Historic England

28 August 2018

**BICESTER HERITAGE BUCKINGHAM ROAD BICESTER
Application No. 18/01253/F**

PROPOSED ELEVATIONS

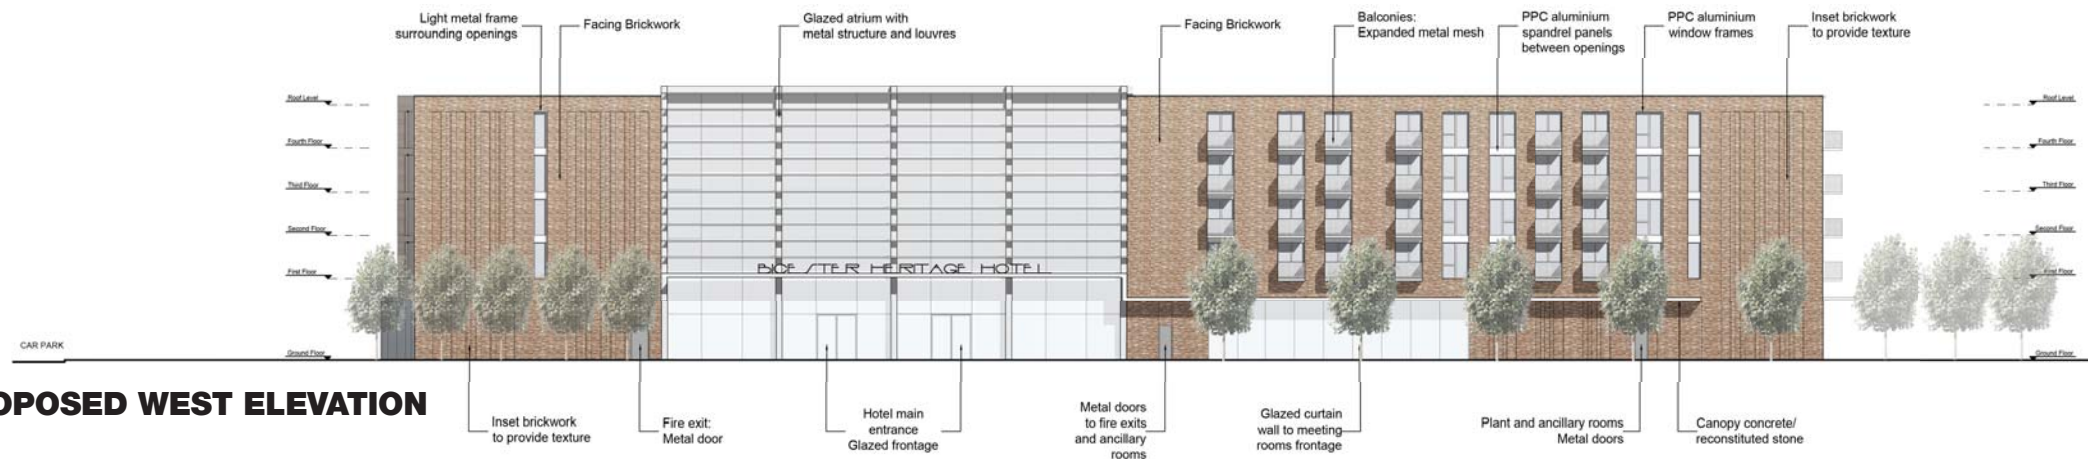
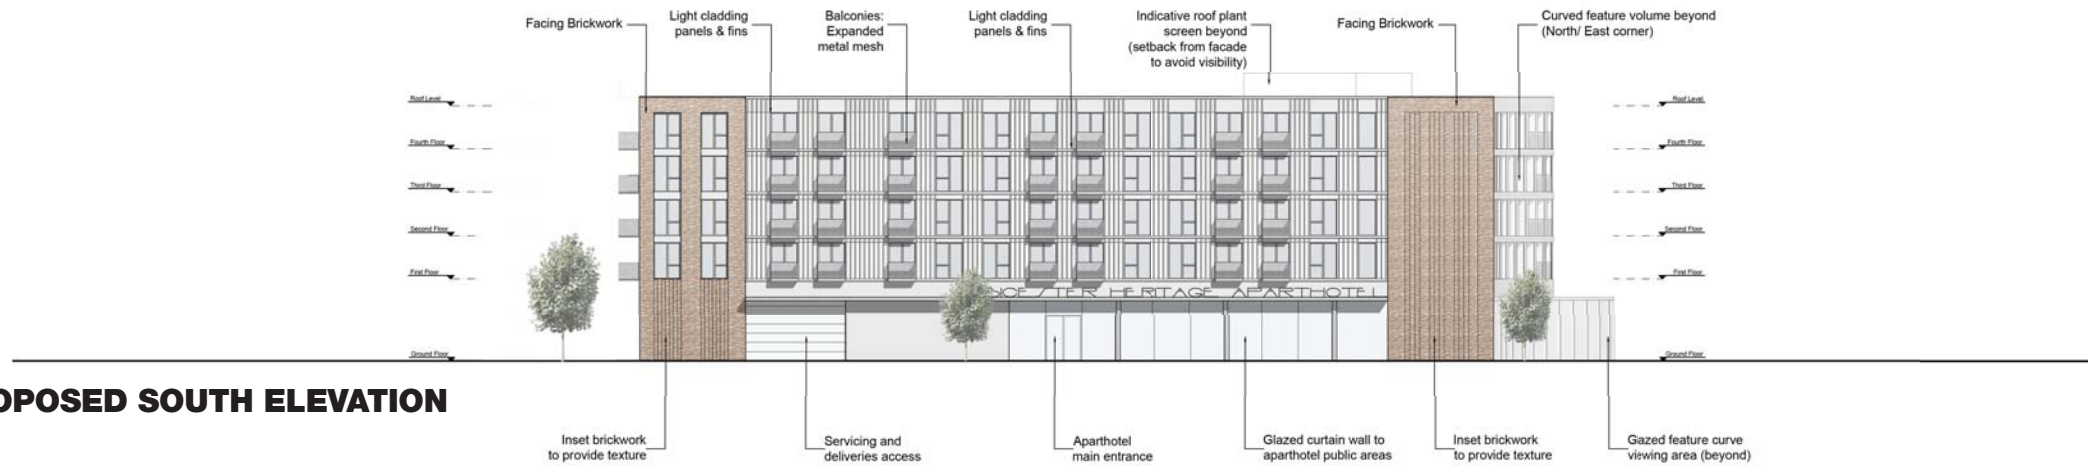
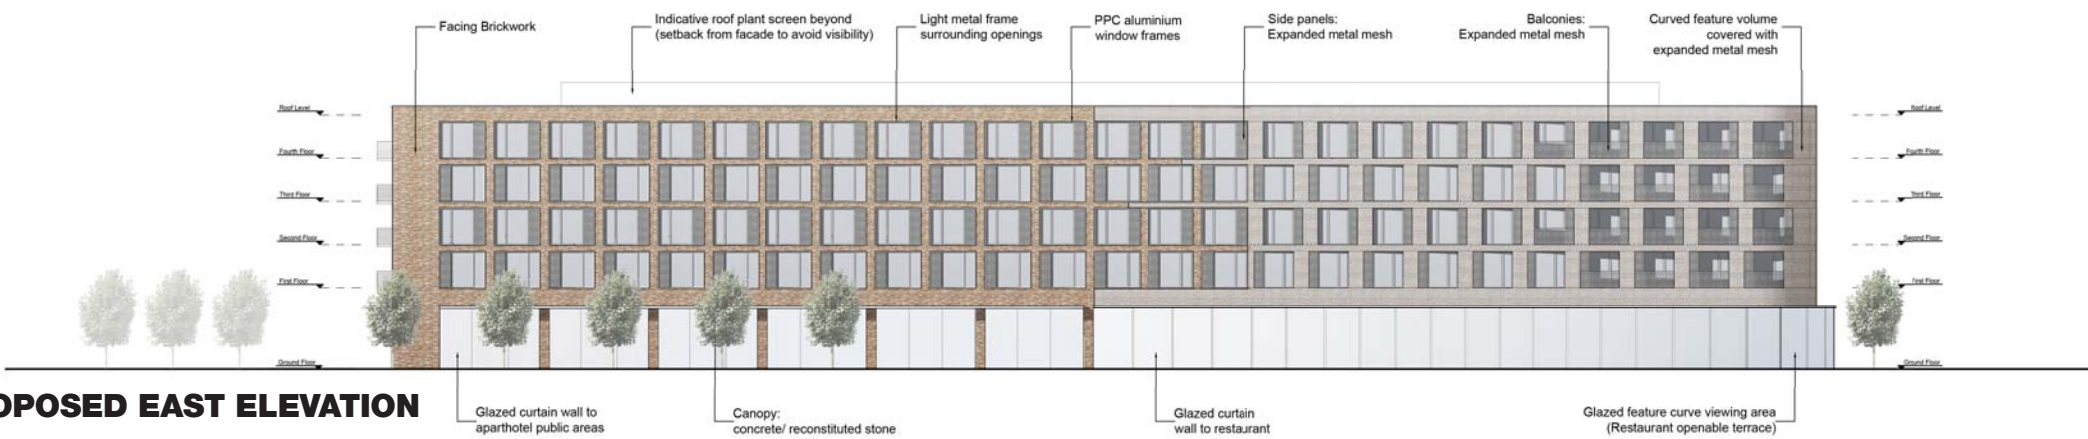
The architects have been wrestling with the challenge of making this building conform to the massing of a C-type hanger and look like it belongs as part of the base without looking too much like a hanger. After all a hotel needs to look inviting. I think the south elevation achieves this reasonably successfully. The contrast between the brick ends and cladding centre gives the elevation a very clear structure and evokes the doors of the hanger. The west elevation works reasonably well in that it reads as a more solid elevation, which again effectively evokes a hangar, while the contrast between the strong corners, with plain walls enlivened by inset brickwork, and the more open centre works reasonably well at creating an interesting and balanced elevation. The other elevations are less successful. The curved corner does not sit comfortably with the strong, simple rectilinear form of the building, the transition from brick to metal mesh looks awkward and their composition, of very regular window openings with little surface modulation, is likely to appear overpowering on this scale.

I think that if the architects were given a bit more time, and pushed a bit harder, they could refine these elevations and produce a much better building here. It would be worth thinking further about how interest could be provided on this side of the building without resorting to the curved corner. One possibility would be to look at expressing the grid which frames the elevation more clearly, possibly by introducing more depth - recessing the windows or bringing the grid forward in places, while having less depth in other area, for instance at the corners.
